Recommendation Report for Works to Tree(s) on trees subject to a Tree Preservation Order (TPO)

REF NO: AL/16/18/T

LOCATION: 16 Woodgate Road
Woodgate
ALDINGBOURNE
PO20 3SX

PROPOSAL: 3m Crown Reduction and 30% Crown Thinning to 1No. Hawthorn & 2No. English Oak trees.

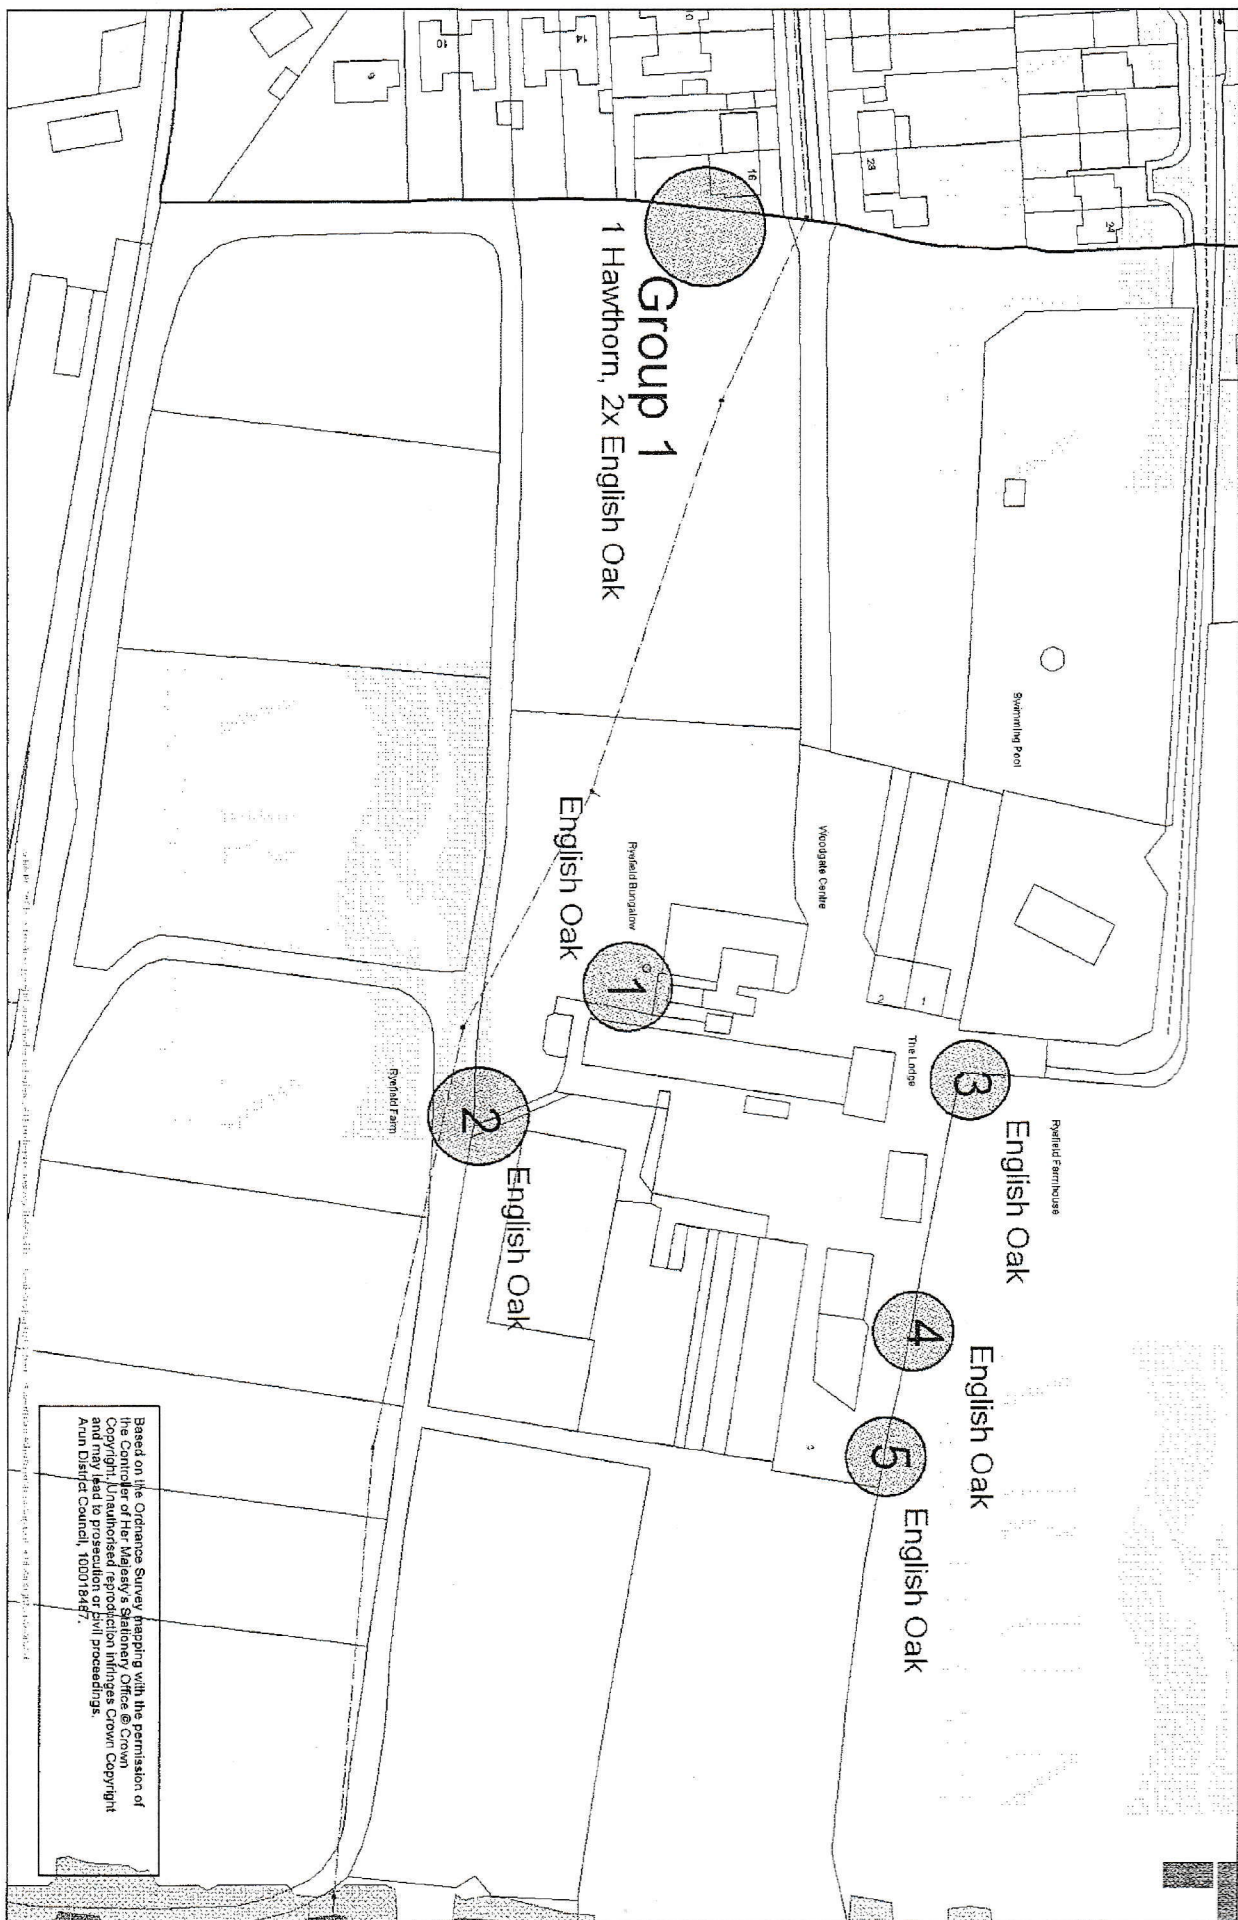
- These are fine examples of their type and visible from the adjacent public highway and neighbouring properties; thereby providing a notable visual amenity.
- In respect of the oak, they have good form arising from a lack of significant crown modification and with an open field aspect permitting the establishment of low branches. Although not comprehensively assessed, they appear to be in a fine physiological state and free of significant structural defect. As old field boundary trees they possess considerable landscape value.
- The oak are closely spaced to one another with a shared crown profile. Their relatively short distance to the main building has inevitably caused an intensely shade-bearing and oppressive effect with large branches travelling across and in close proximity to the roof and east flank wall.

- Crown reduction and Crown thinning work has not been justified on arboricultural grounds. In respect of the latter, such work rarely provides a benefit to the tree and often only a short-term increase in light levels. Furthermore, combining the two operations (and especially to the extent proposed) could drastically alter tree dynamics and natural defences against wind pressure. The sudden exposure of central crown areas to such winds can result in significant damage.
- These trees are a significant feature in the local landscape and appear to be in adequately sound and healthy condition. The tree surgery proposed in the application would result in excessive reduction of the tree's landscape impact and undue detriment to the visual amenities of the locality.

1 The trees are a significant feature in the local landscape and appear to be in adequately sound and healthy condition. The tree surgery proposed in the application would result in excessive reduction of the trees landscape impact and undue detriment to the visual amenities of the locality.

- I would like to see the applicant re-submit with a revised work specification such as detailed below, which would address the issue of direct building interference and help improve conditions along this side of the dwelling whilst preventing a diminution of the tree's landscape and public amenity value:

2x Oak

- Reduce or remove branches as necessary to achieve a maximum of 2m building clearance.
- Reduce or remove branches as necessary to achieve a maximum of 4m overhead clearance above side of property (driveway and garden areas).

Hawthorn

- Reduce or remove branches as necessary to achieve a maximum of 3m overhead clearance above driveway.
